Ein cyf / Our ref: SH/2014/117386/6

**DEVELOPMENT CONSENT ORDER FOR INTERNAL POWER GENERATION
ENHANCEMENT FOR PORT TALBOT STEELWORKS**

**RESPONSE TO THE EXAMINING AUTHORITY'S SECOND ROUND OF
QUESTIONS**

PROJECT REFERENCE: EN 010062

Figure 14.2.1 WFD83 River Flow Objective Relative to River Afan Flow at Marcroft Gauging Station Upstream of the Applicants Abstraction

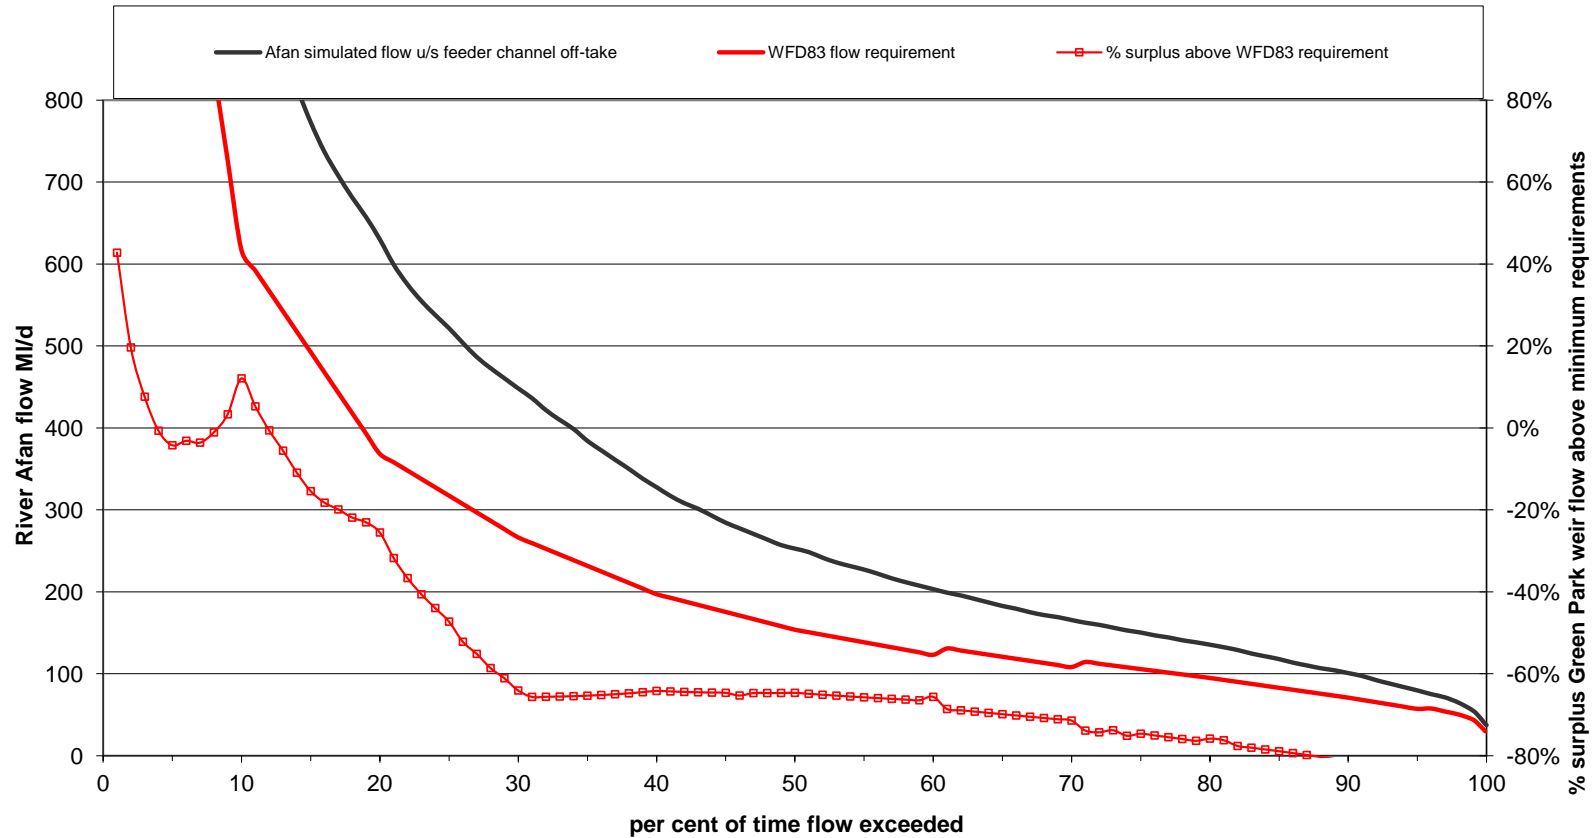
The lower Afan has historically experienced extended periods of low flow as a result of flow entering the Docks Feeder Channel for industrial abstraction or navigation within Port Talbot Docks. The 2010 study carried out by Halcrow modelled Afan River flows and compared them with our desired environmental river flow objective to meet WFD standards. The study identified a number of factors that could be addressed to reduce abstraction demand from the river and increase residual flows downstream of Greenpark Weir. Those resulting in the greatest improvement to residual flows were repair to leaking Dock lock gates, installation of a control system to the intake to the Docks Feeder and re-use by Tata of wastewater from the DCWW sewage treatment works. ABP have already replaced the lock gates and are planning installation of the control structures. These actions aimed to increase the efficiency of water use by reducing waste and optimising the benefit of alternative, additional water sources.

As part of our Restoring Sustainable Abstractions Programme that sits within WFD, Halcrow also carried out a cost benefit analysis of the Tata Steel abstraction that compared the economic benefits of increased flows in the lower Afan with the economic value of the water to Tata Steel as an industry and costs of replacing licensed Afan water with alternative sources. The purpose was to see whether we should be seeking to reduce Tata's abstraction licence volumes for environmental benefit. It concluded that it would be disproportionately costly for Tata to develop alternative sources of supply which under WFD is an appropriate justification to not pursue licence changes. The Tata abstraction from the Docks Feeder does influence the rate of residual flow in the Afan and is one of the contributing factors affecting the ability of the Afan to meet WFD flow objectives, although not the most significant. The analysis showed though that economic value of the water to industry is high and that we will not be seeking to reduce licence volumes to meet our WFD objectives.

We have focused our effort on working with the partners in the Afan Water Management group to increase the efficiency of water management in the system by better control and reduced leakage to increase residual Afan flows but also to increase security of supply to both Tata Steel and Port Talbot Docks.
